**Application by Highways England for an Order Granting Development  
Consent for the A63 Castle Street Improvement Scheme**

**PINS Reference TR010016**

**WRITTEN REPRESENTATION OF EPIC (NO.2) LIMITED**

**KINGSTON RETAIL PARK**

Drawing Title **LAND PLANS REGULATION 5(2)(i) OPTION A SHEET 3 OF 6**

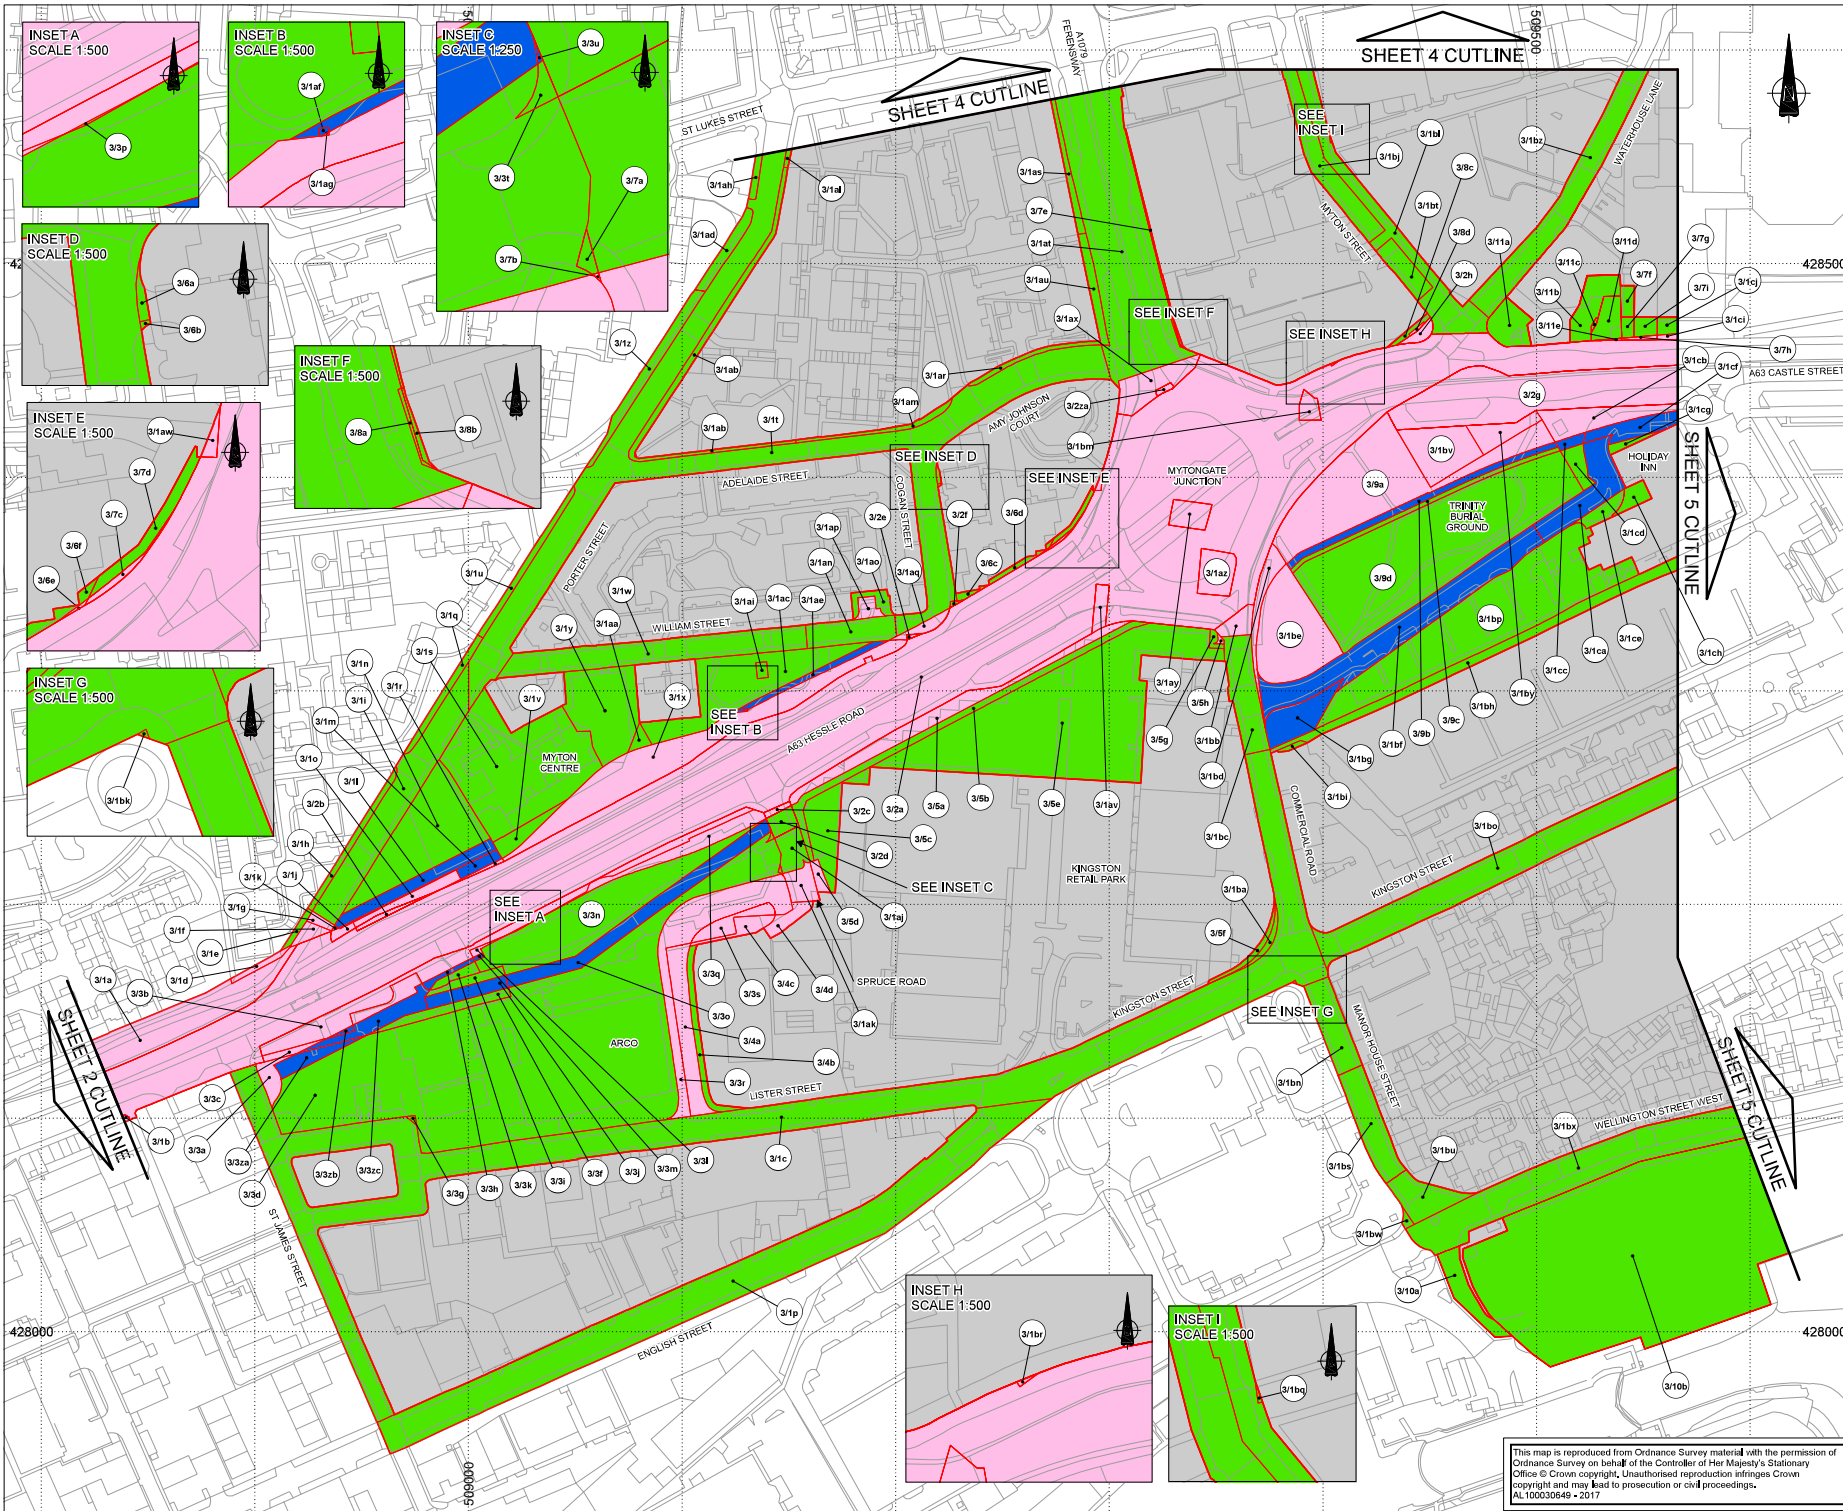
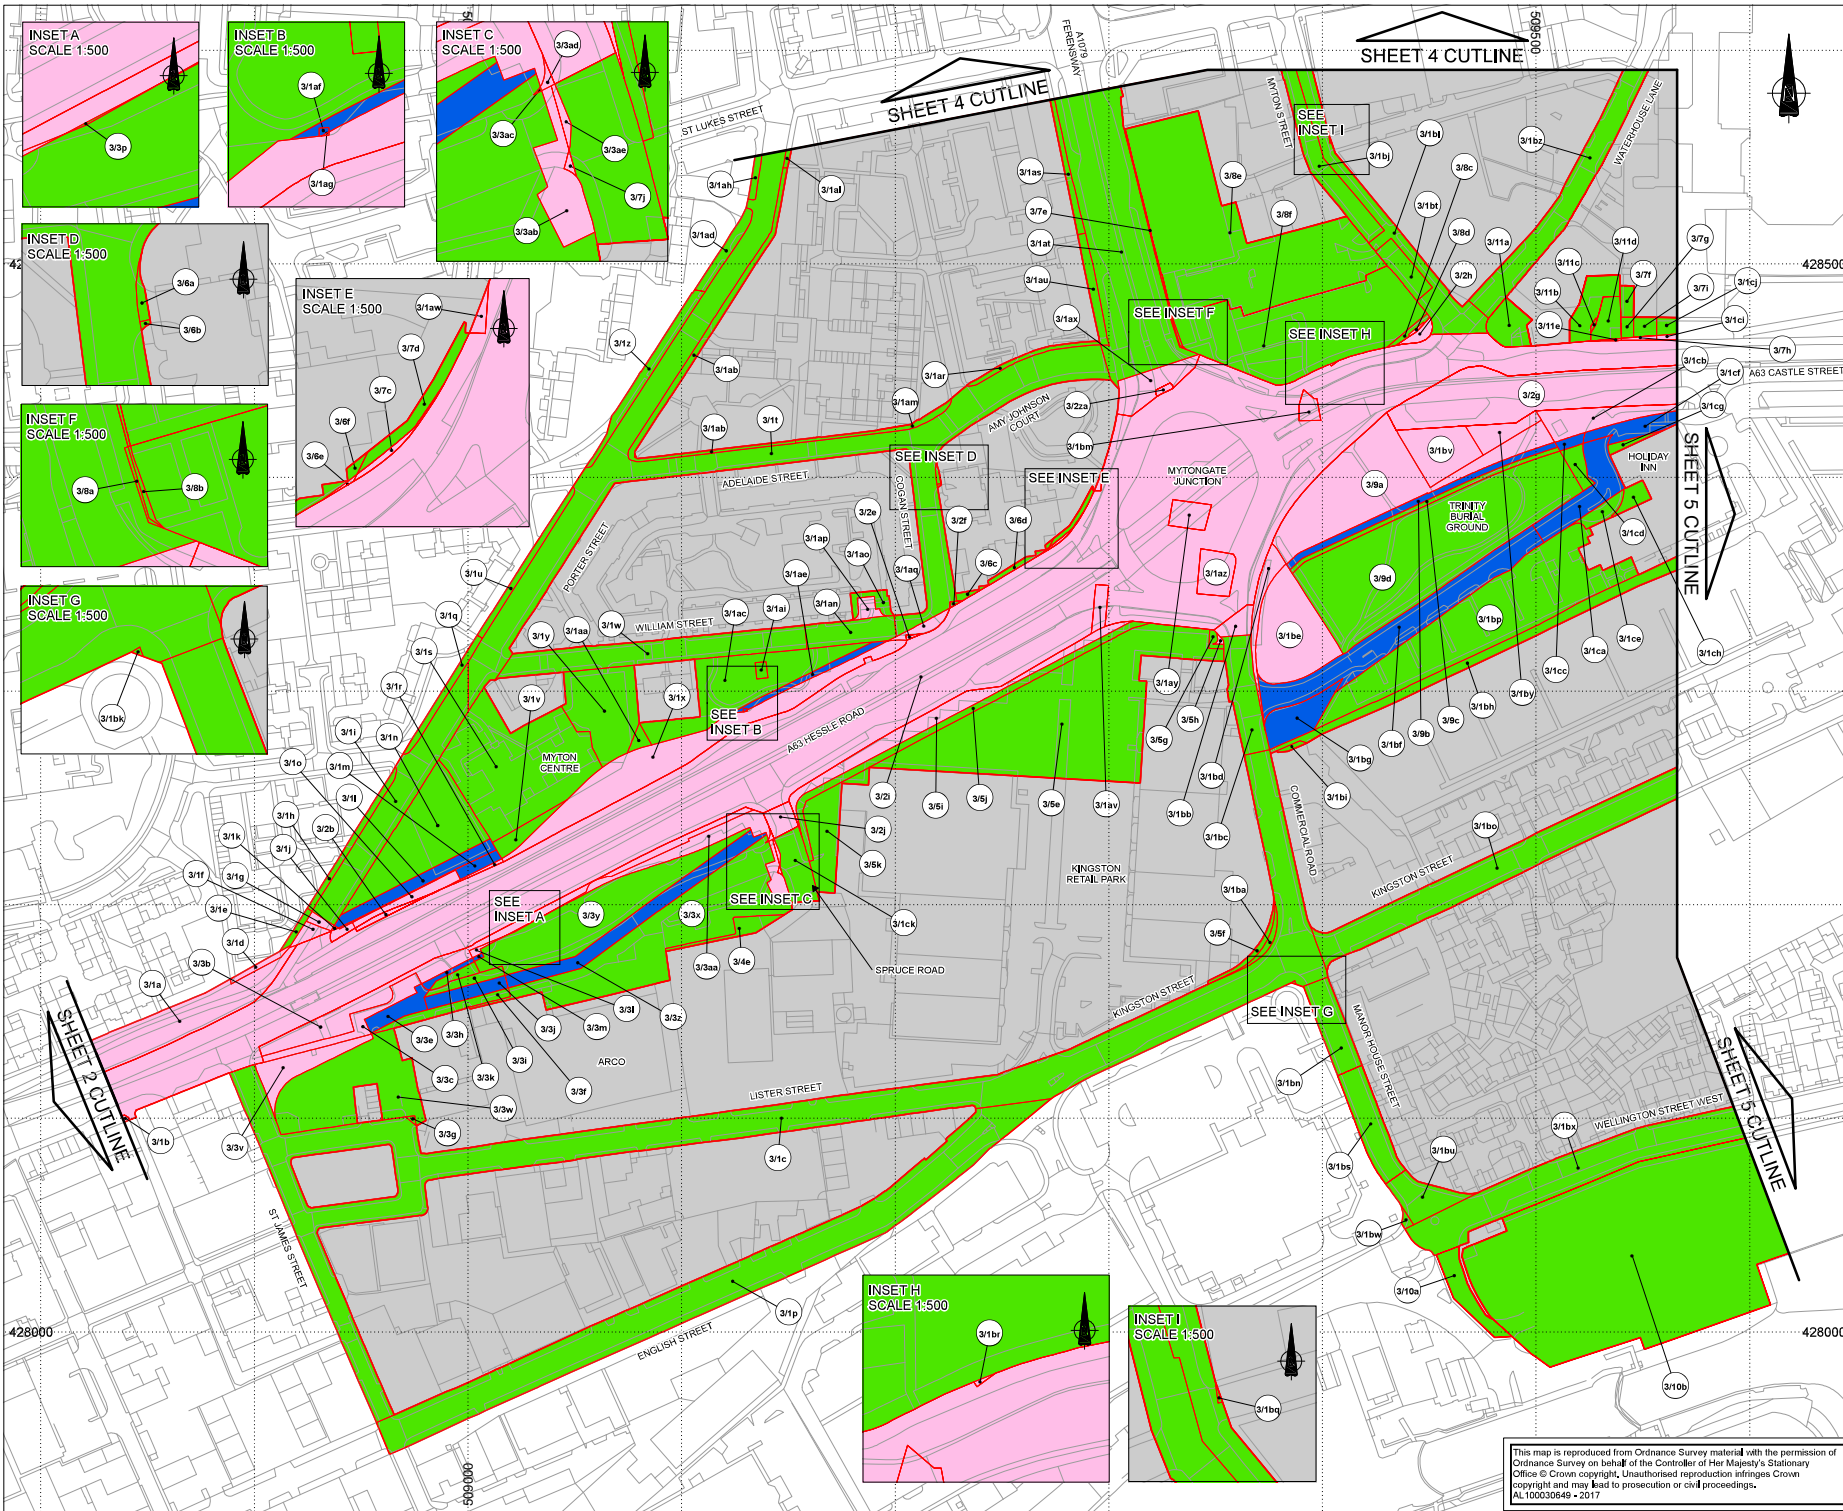
- 5.2 An example of the 'broad brush' approach relates to Work number 18 and the temporary possession of (amongst others) plot number 3/5e (5,326 square metres) which is the majority of the northern end of the main car park, including up to the front entrances of units occupied by Mothercare and Carphone Warehouse, as well as plot 3/5c (620 square metres) which includes the northern end of the service yard for Kingston Retail Park. The period of temporary possession is unlimited other than by Article 29 of the proposed Order<sup>6</sup>. The justification for the possession of such a large area for an unlimited period is unclear<sup>7</sup> but appears to be on the basis to ensure 'flexibility' for Highways England should it want to provide amendments to the car park and service yard layout as it sees fit. The consequences of the possession of these plots for the entire construction period (as has to be assumed) on the interests of EPIC and their tenants would be clearly excessive and disproportionate to the public interest. This is far from the "clear idea" that the statutory guidance<sup>8</sup> requires Highways England must have of how this land is intended to be used.
